**From:** [REDACTED]  
**Sent:** 11 June 2022 13:16  
**To:** Planning  
**Subject:** Planning Application 3/2022/0414

**Address of Development:** Carr Hall, Whalley Road, Wilpshire BB1 9LJ

**Comments:** I would like to object to the proposed development of 'Proposed electric quad motorsport facility with support building and car park' because of similar concerns as others such as visual impact on the openness of the greenbelt and whether it is essential to develop the greenbelt for this use.

GROUND FLOOR
PROPOSED PLANS
SCALE 1:100 A2

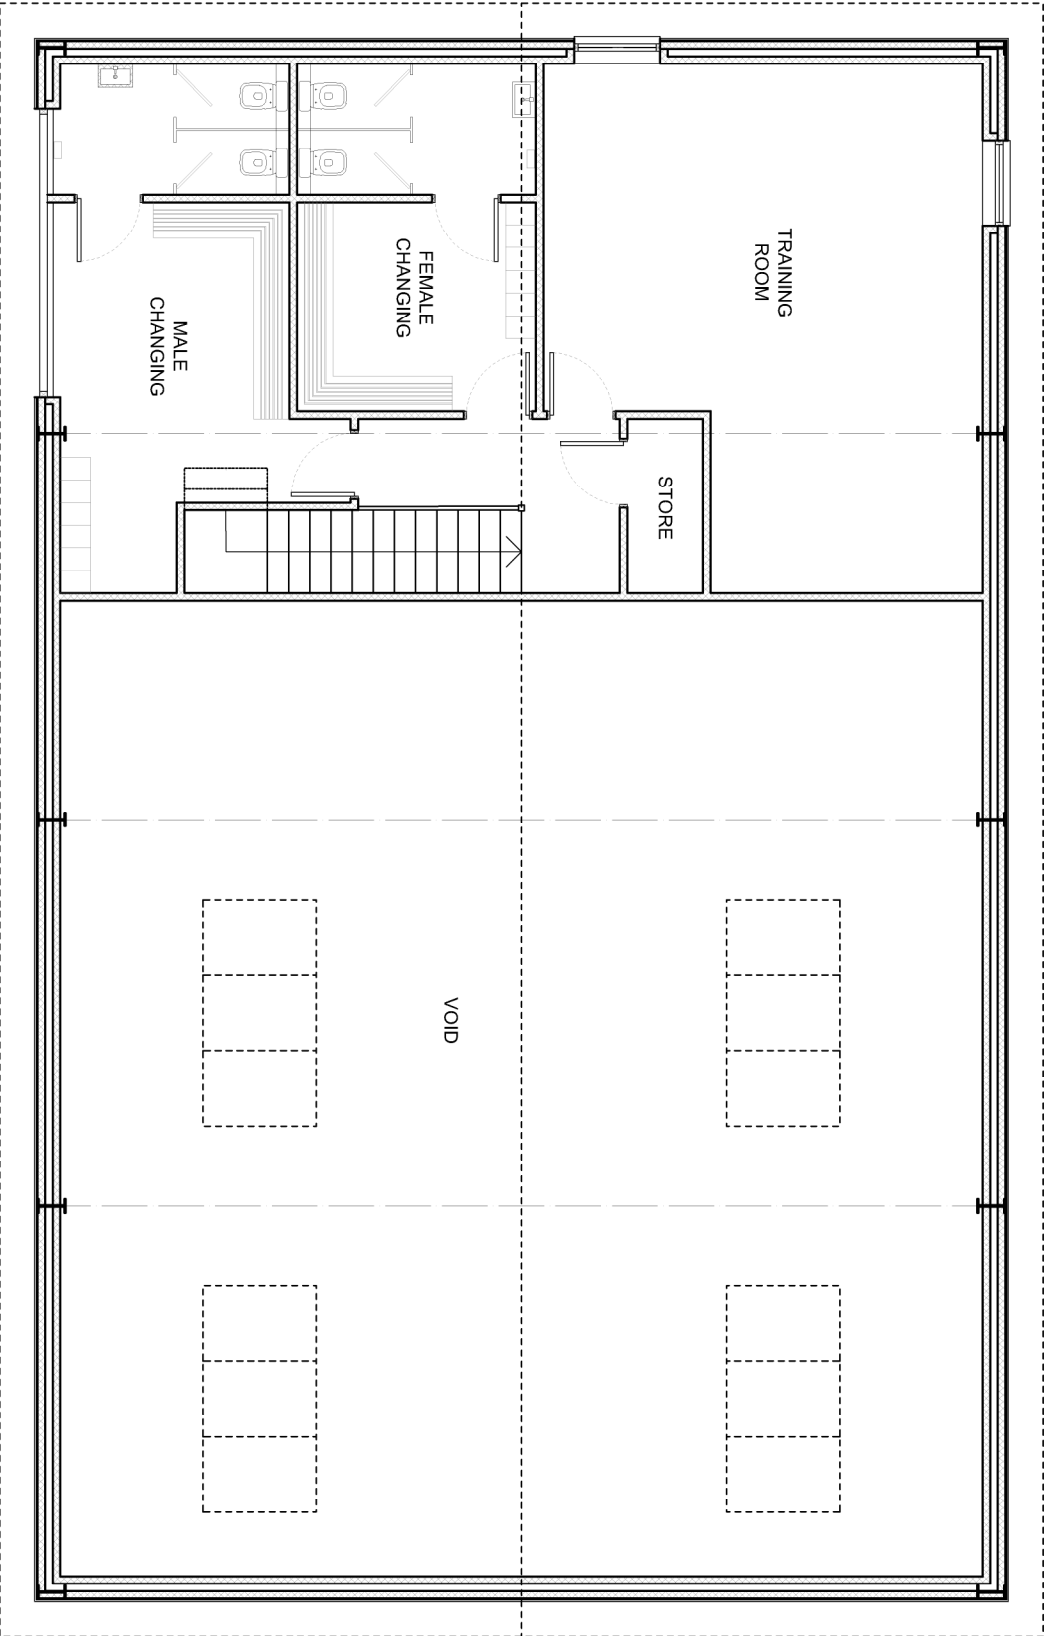
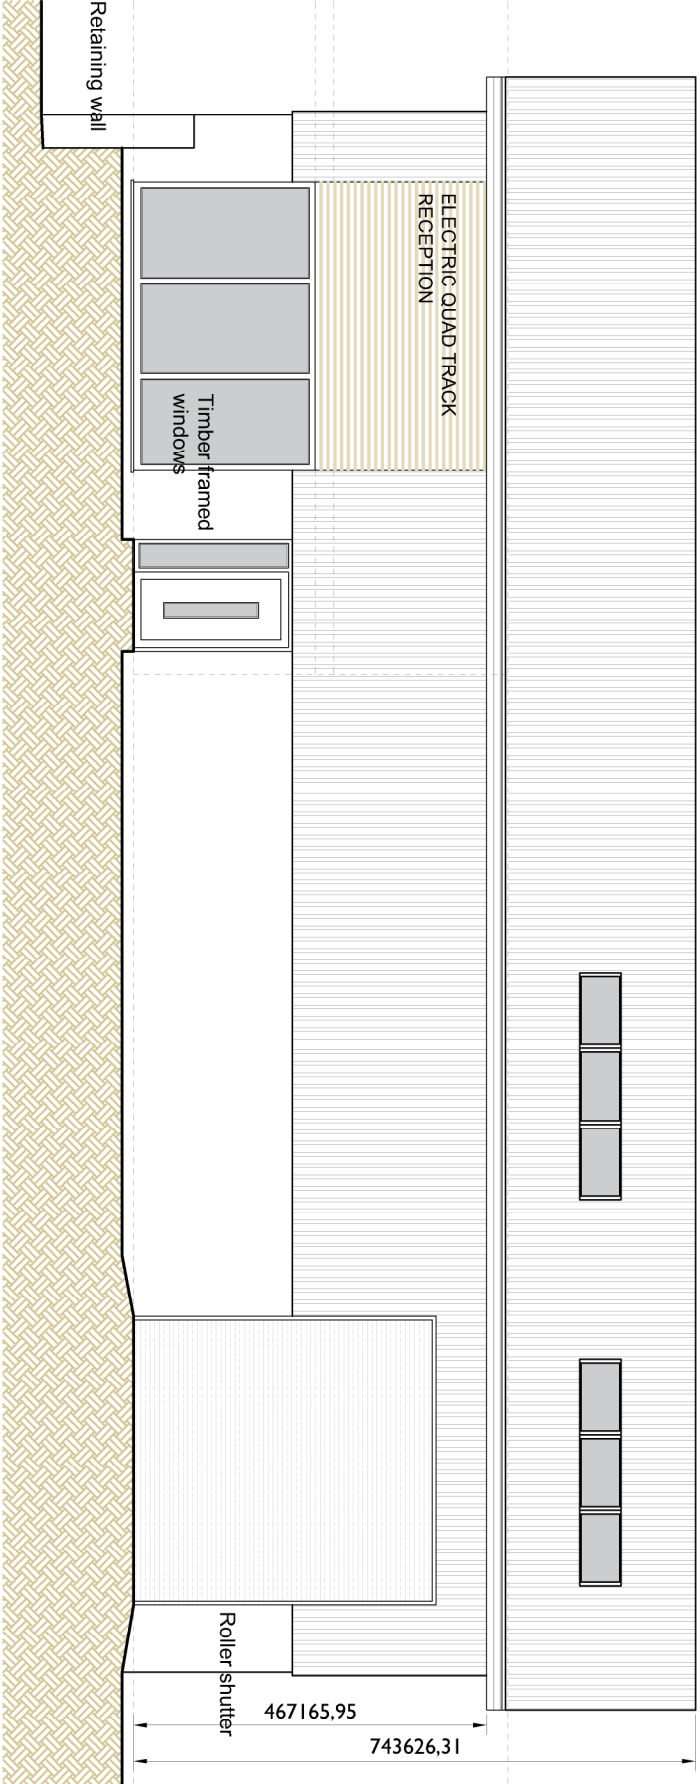
It is noted that the business plan provided identifies that people can purchase bikes and accessories within the proposed building, the proposed development plans show a 'electric bike store/repair shop' so it is unclear if this area used for repairs or retail? Is retail such as this permitted within the greenbelt?
